**Our Ref: P/66/19/HH**

**Town & Country Planning Act 1990 (as amended)  
Town & Country Planning (Development Management Procedure) (England) Order 2015  
Application for Planning Permission for Works or Extension to a Dwelling**

**Development**     Ground Floor Rear Extension

**Location**         34 Greenways Pagham

North Elevation ProposedNo existing rear North elevation 1:100

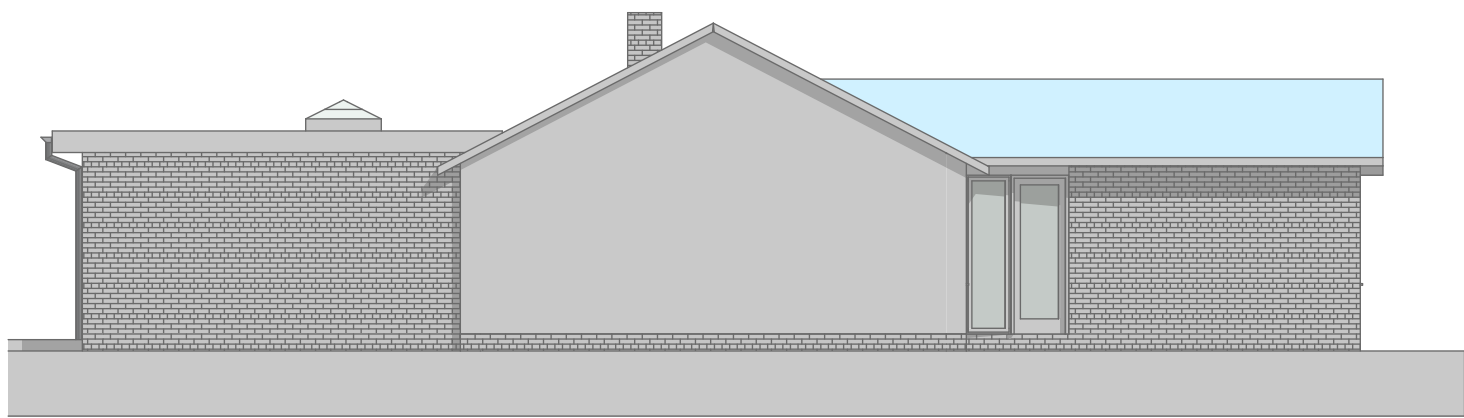
Other Side Elevation: Please provide the other side elevation for the extension. Please submit this at a standard scale of 1:50 or 1:100.

1,500 Block Plan 1:500

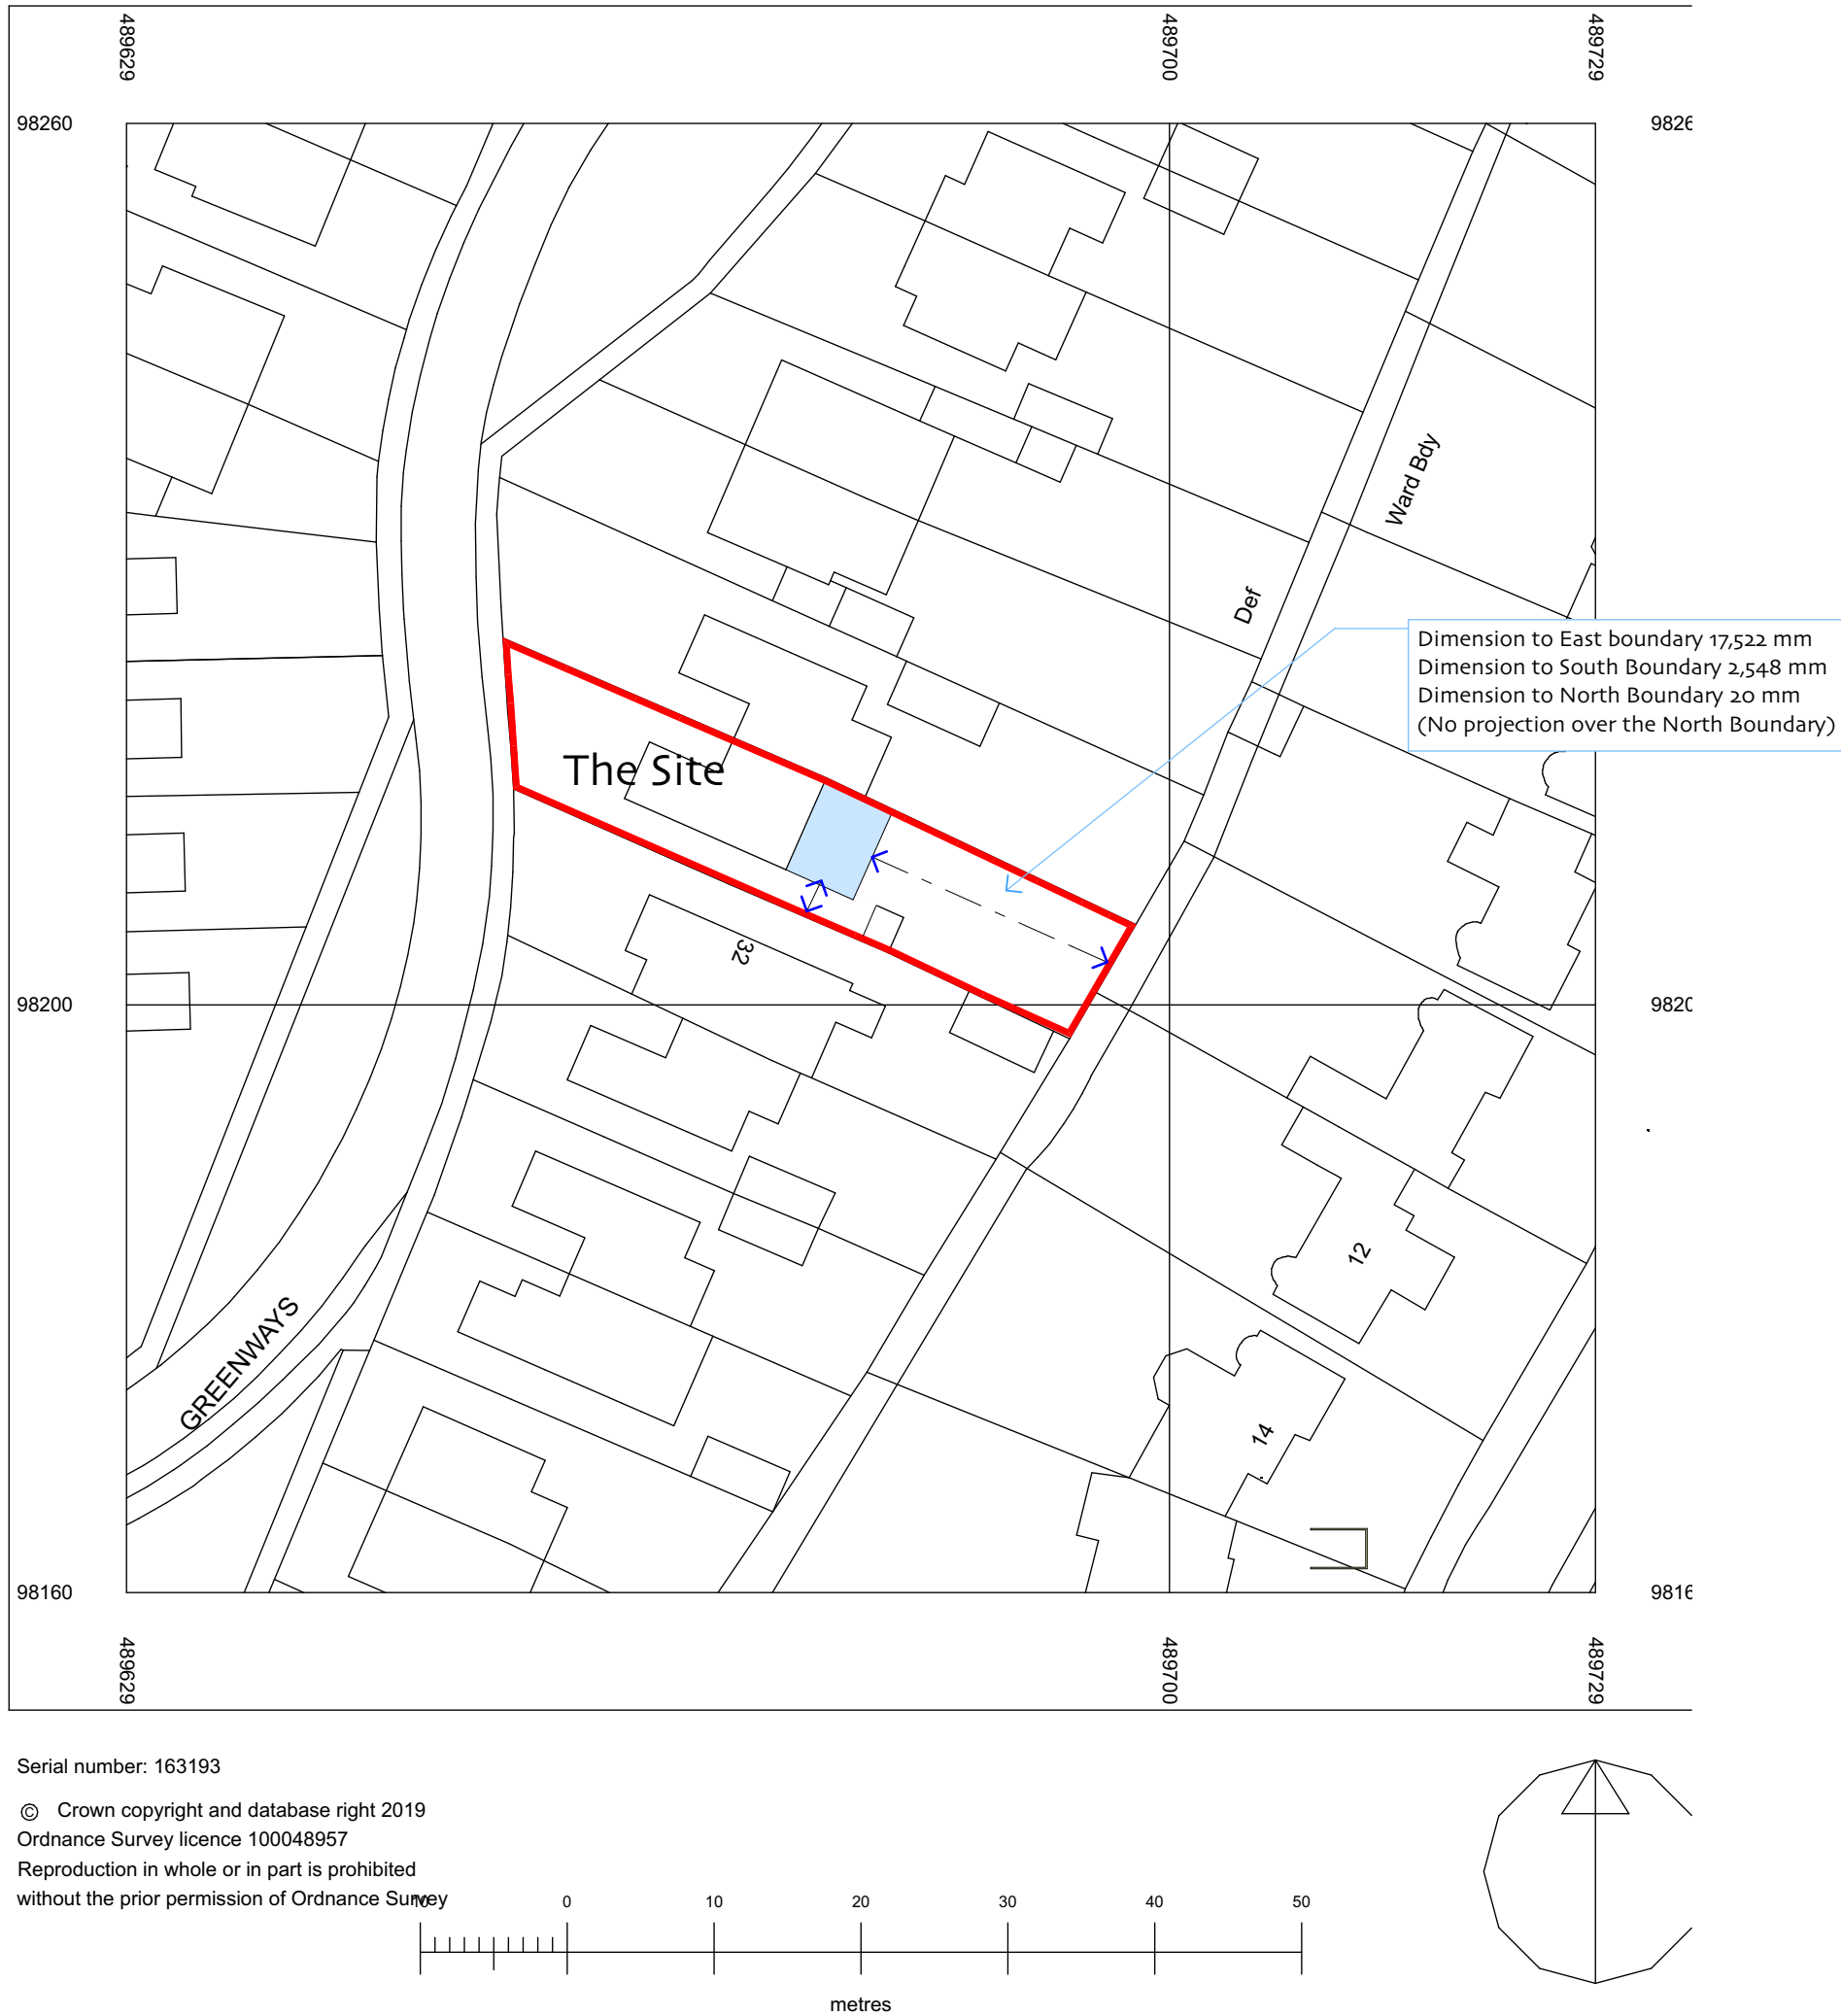
Block Plan

Please submit a block plan which includes dimensions from the proposed extension to the site boundaries.
